Application Ref:	3/2025/0643			 Ribble Valley Borough Council www.ribblevalley.gov.uk
Date Inspected:	25/09/2025	Site Notice:	25/09/2025	
Officer:	MC			
DELEGATED ITEM FILE REPORT:				APPROVAL

Development Description:	Planning permission for proposed conversion of Barn 2 within the curtilage of the listed Writtenstone Farmhouse, into ancillary residential accommodation. Works to include insertion/infilling of window and door openings, replacement of cement fibre roofing with slates and engineering operations to include the lowering of the ground level adjacent to the barn.
Site Address/Location:	Writtenstone Farm, Writtenstone Lane, Longridge, PR3 2ZN.

Planning Application  
 Proposed Plans and Elevations

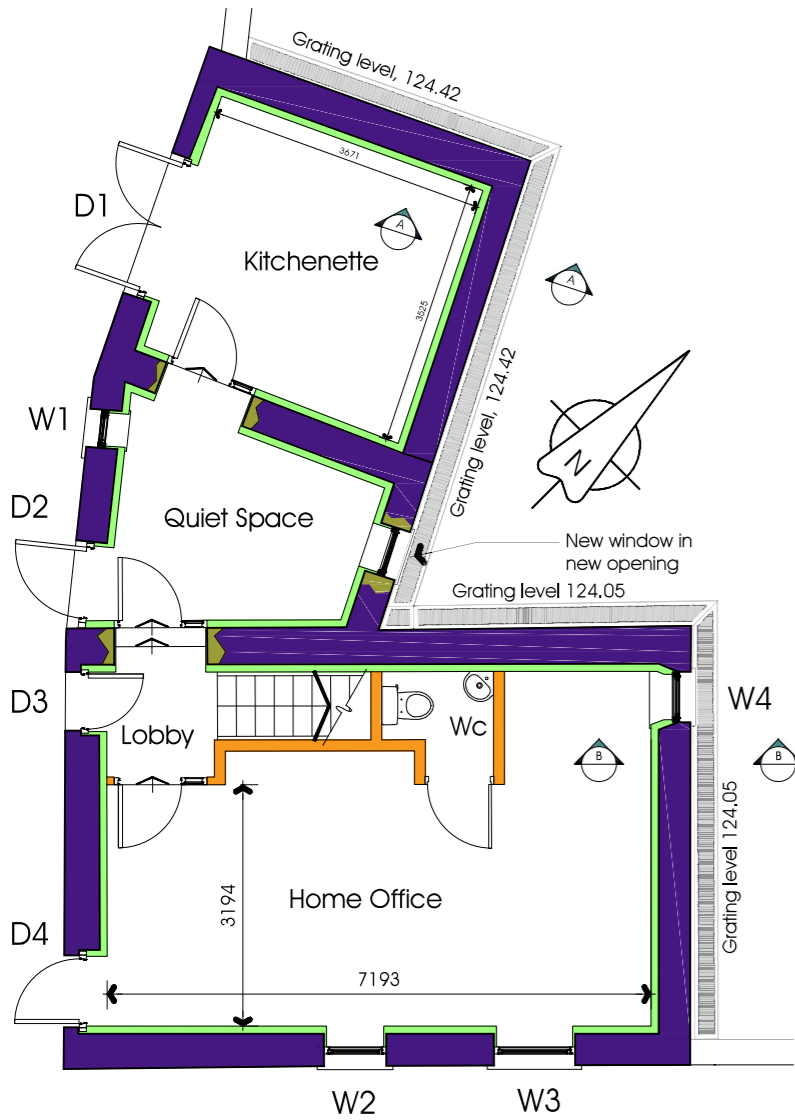
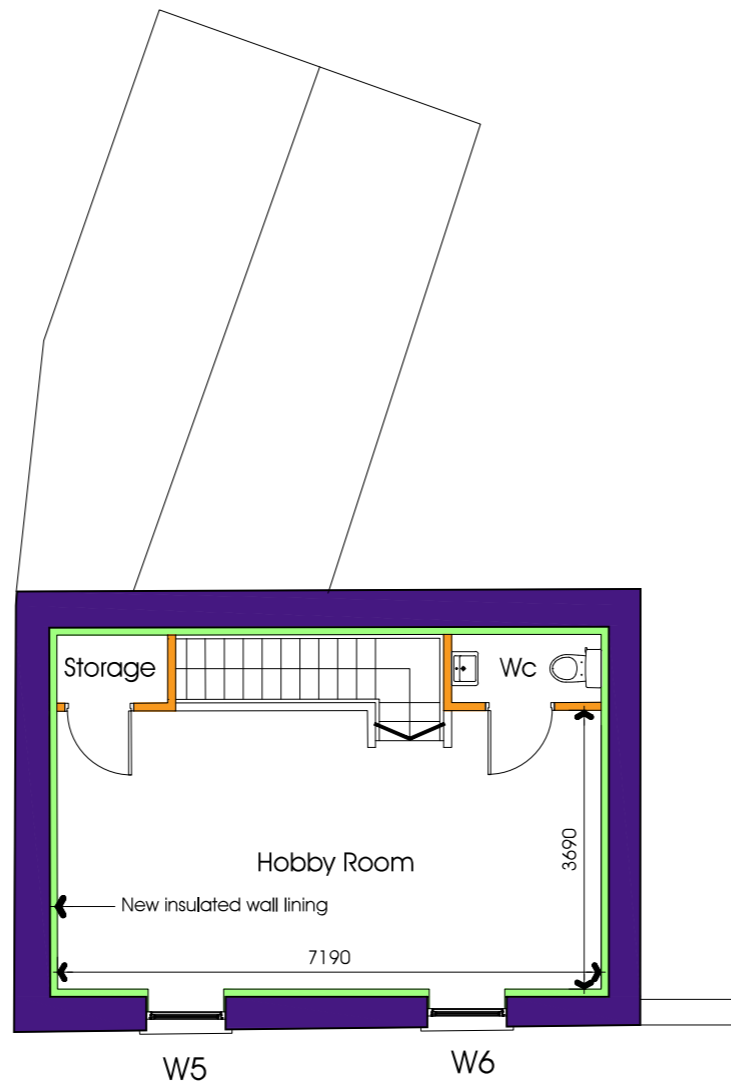
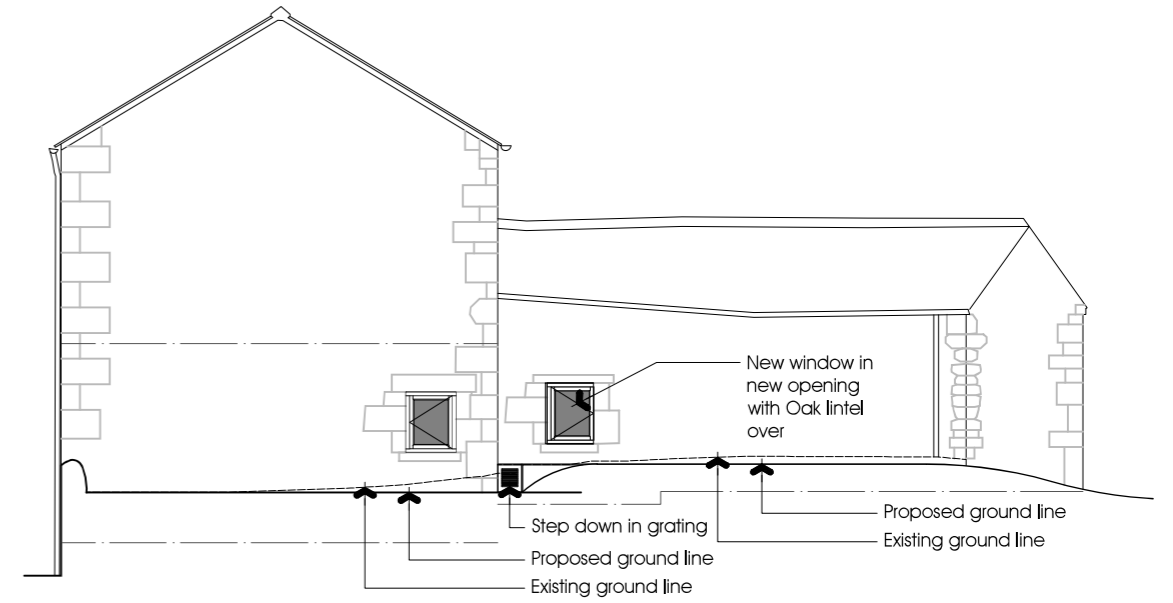
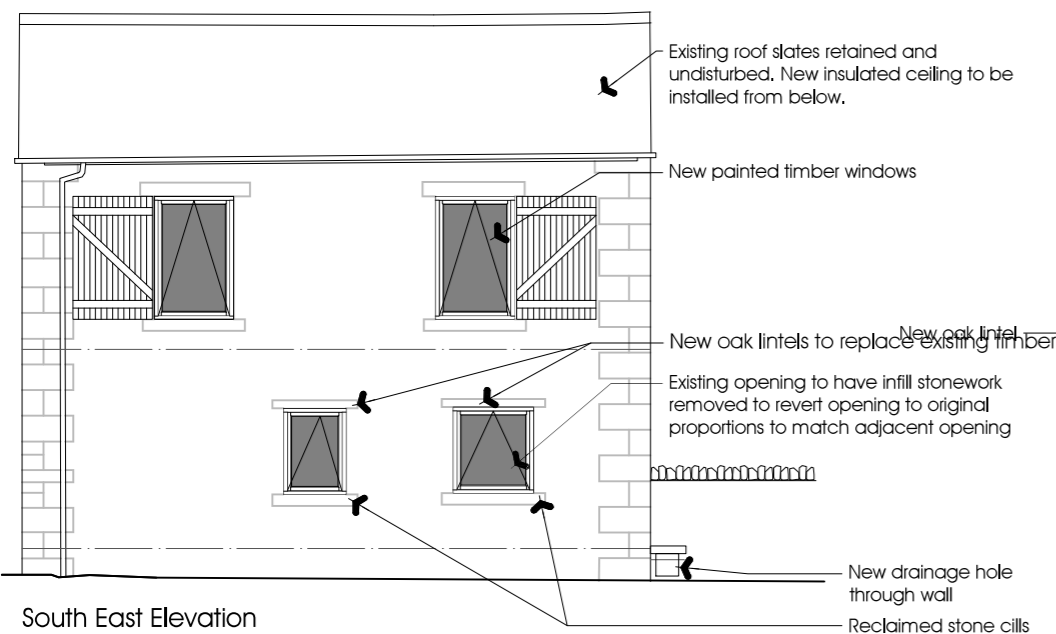
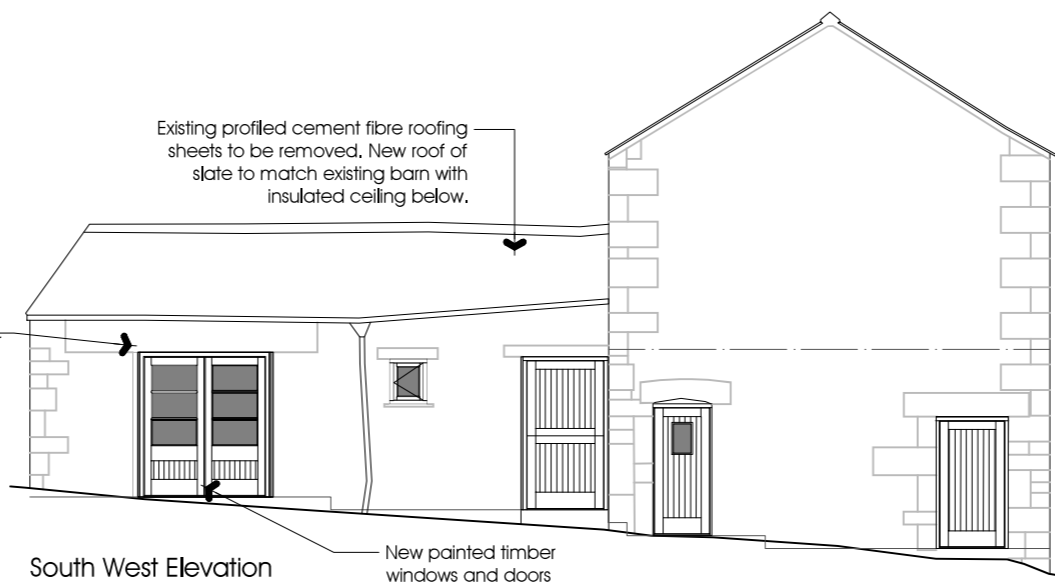
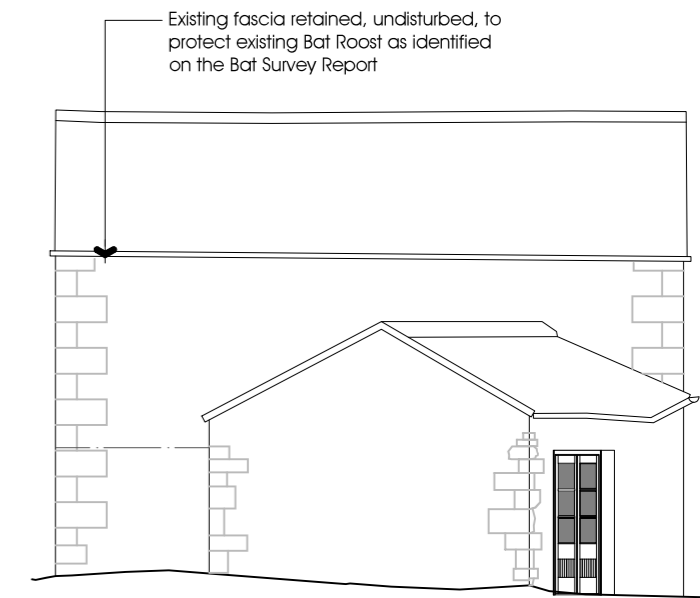
In terms of the proposed doors and windows, they note that the applicant has reviewed a previous design of doors/windows to match the farmhouse, which was considered to be contrary to the agricultural character of the barn. The proposed amended windows are to be simple plain glazed timber framed casements, and the doors along the SW elevation are to be replaced with good quality timber with design and glazing taking cues from the ad hoc existing arrangement of doors that will help to retain the agricultural character. No objection is raised to the new window proposed also.

Planning Application  
 Proposed Site & Roof Plan

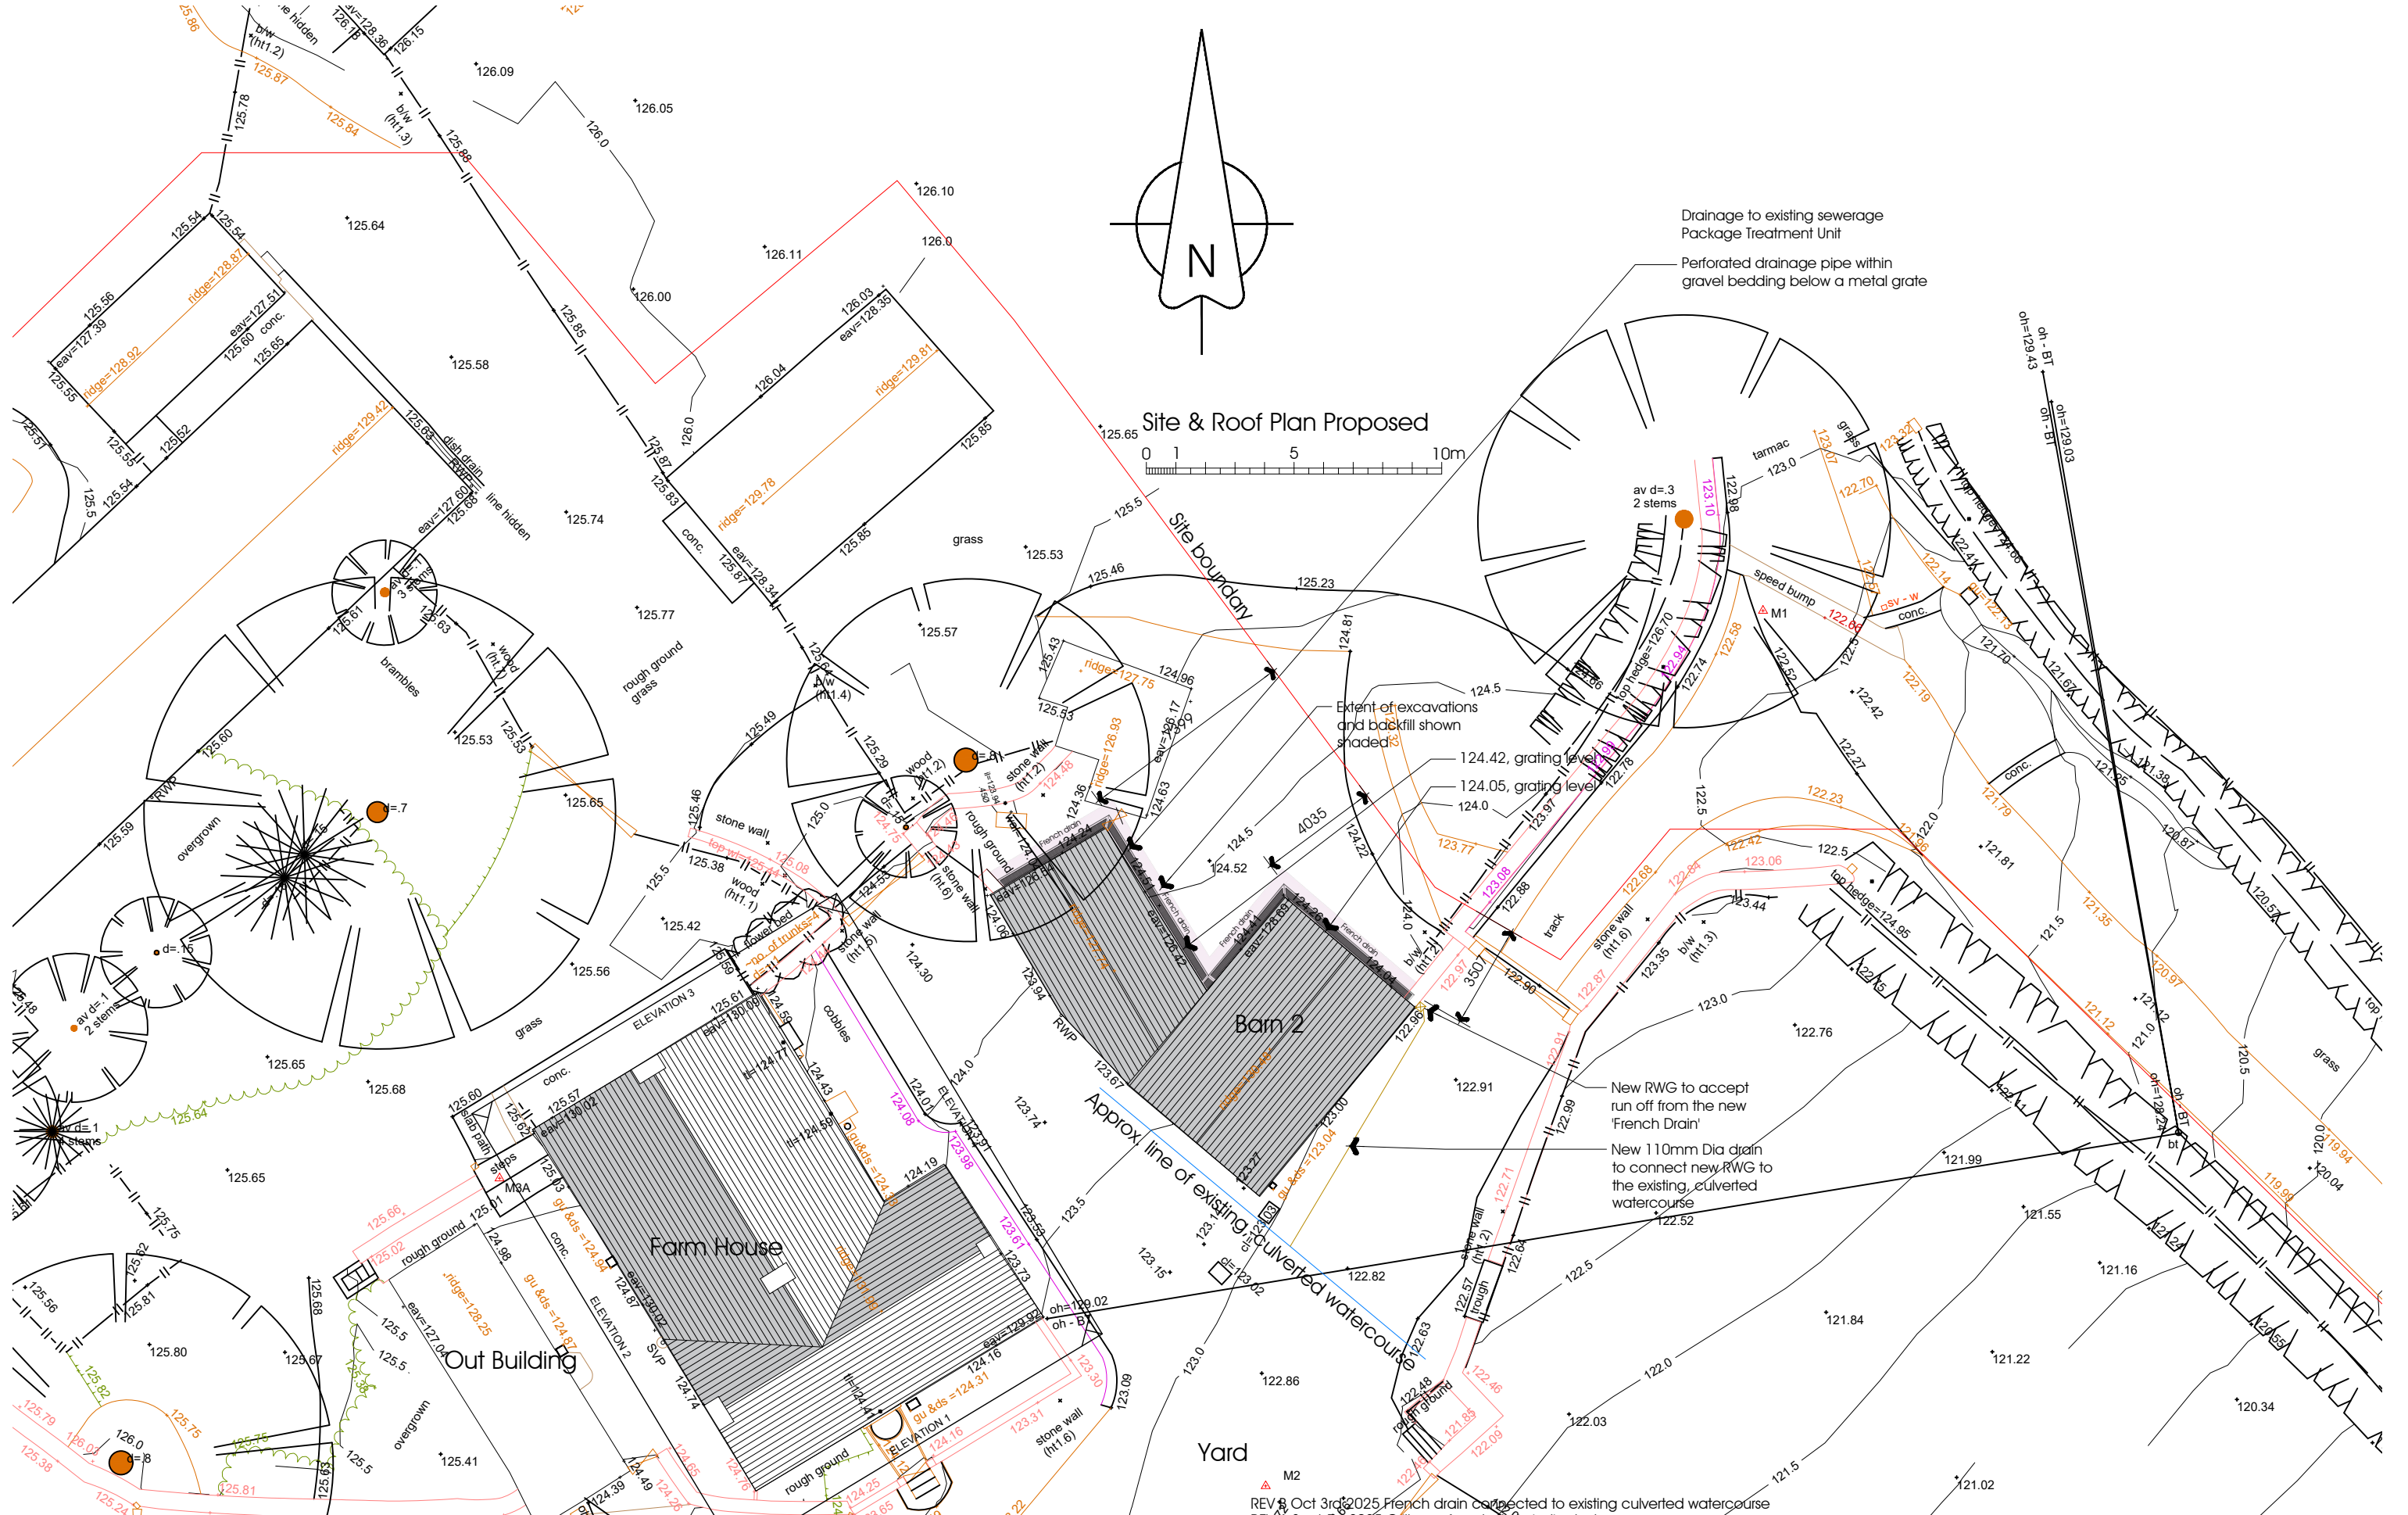
With regards to drainage, following concerns that the French drain would discharge out on to the hard surfaced farm yard/track area, the proposed site plan has been updated and now indicates that the drain would connect to the existing culverted watercourse, which is considered acceptable.
